Planning Application: Seeking advice on an **OUTLINE** planning application for the construction of 56 new dwellings on this site.

Reference: Y/1/17/OUT

Location: Land at Bonhams Field, Main Road, Yapton

drawing: Tree Protection Plan

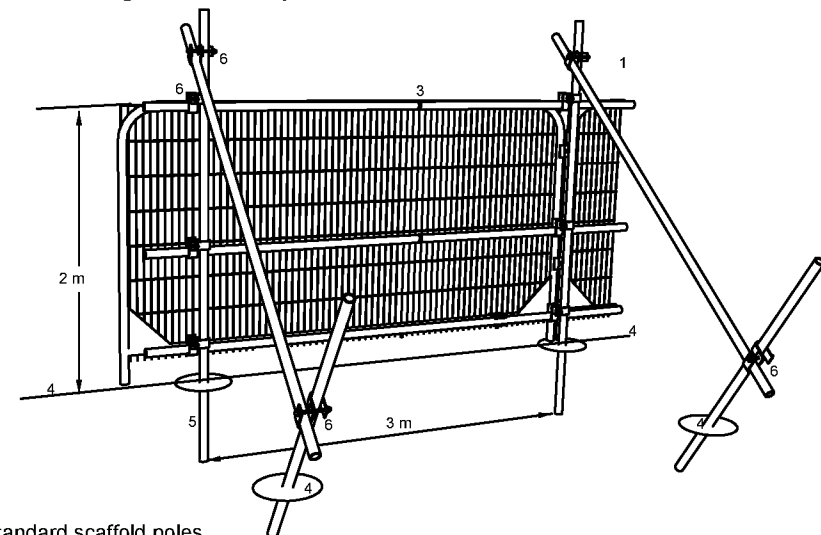
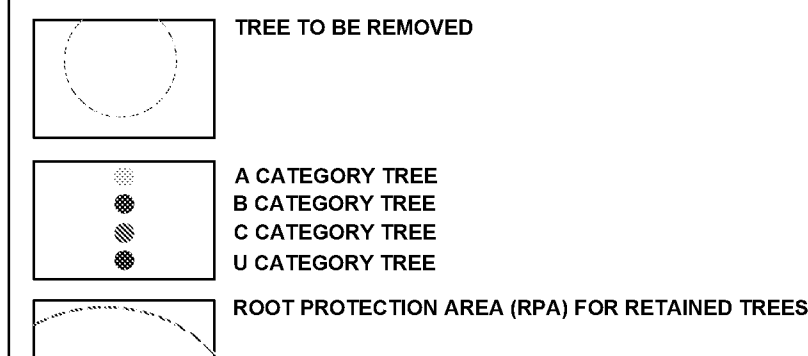
- I have reviewed the site and the Draft Master Plan prepared by **Seawards Properties Ltd.** on which the TP Plan is based— Ref : **SEA20727-03 -1:500@A1-November 2016**.

- I note that wherever possible trees have been incorporated into Open Space areas and where this has not been possible they have been afforded the full RPA protection distances required by BS5837.

- I agree with the condition of T26 & T13 and that they would need to be removed for reasons of sound arboricultural management and safety regardless of any redevelopment proposals.

Arboricultural Method Statement Report Ref: **yet to be prepared and submitted and Tree Protection Plan ref: SEA20727-03 -1:500@A1-November 2016 [subject to this being the final layout otherwise another TP Plan will be needed based on that revised layout].**
